Development Control
Ribble Valley Borough Council

App no: 24.0039

**Address: Land to the rear of Maycroft Cottage and Chipping House Cottage
Hesketh Lane, Chipping**

**Proposal: Proposed drilling of six boreholes for ground source heating
purposes and associated underground pipework.**

DOCUMENT TITLE: Site Plan
 Chipping House and Maycroft House
 SCALE 1:500
 @A3
 22_011-CCE-SP_04/05

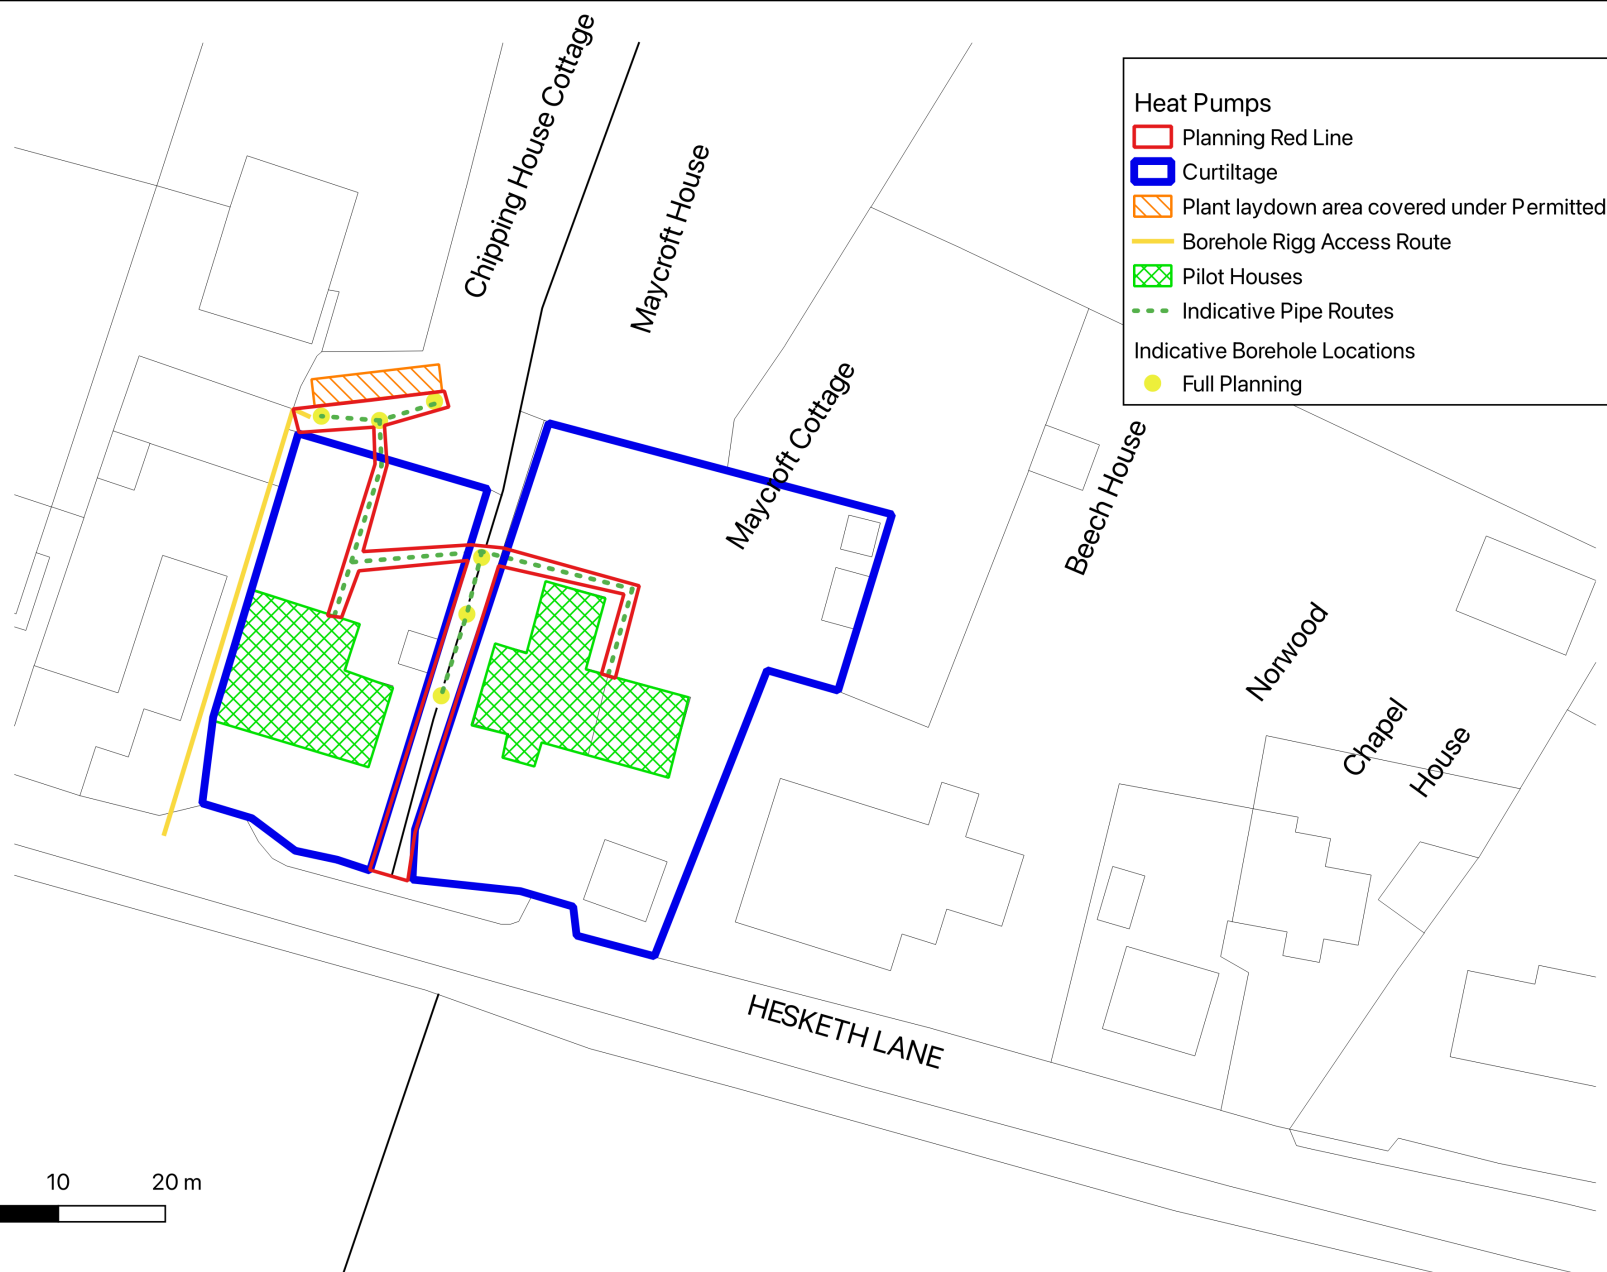
Three of the proposed boreholes are located within the alternative route which is used by walkers which runs from Hesketh Lane in a northerly direction in between Maycroft House and Chipping House Cottage.

The works are likely to cause damage to the grass surface of the route and therefore we would request that pre-commencement and post-completion photographic surveys are completed of the route and that any damage to the surface is repaired and reinstated to its original condition.

2. Pre-commencement and post-completion photographic surveys shall be completed and submitted to the Local Planning Authority for the section of the alternative public footpath route between Maycroft House and Chipping House Cottage. Any damage caused during the development period shall be repaired to its original condition and under an agreed timetable. Reason: For highway safety.
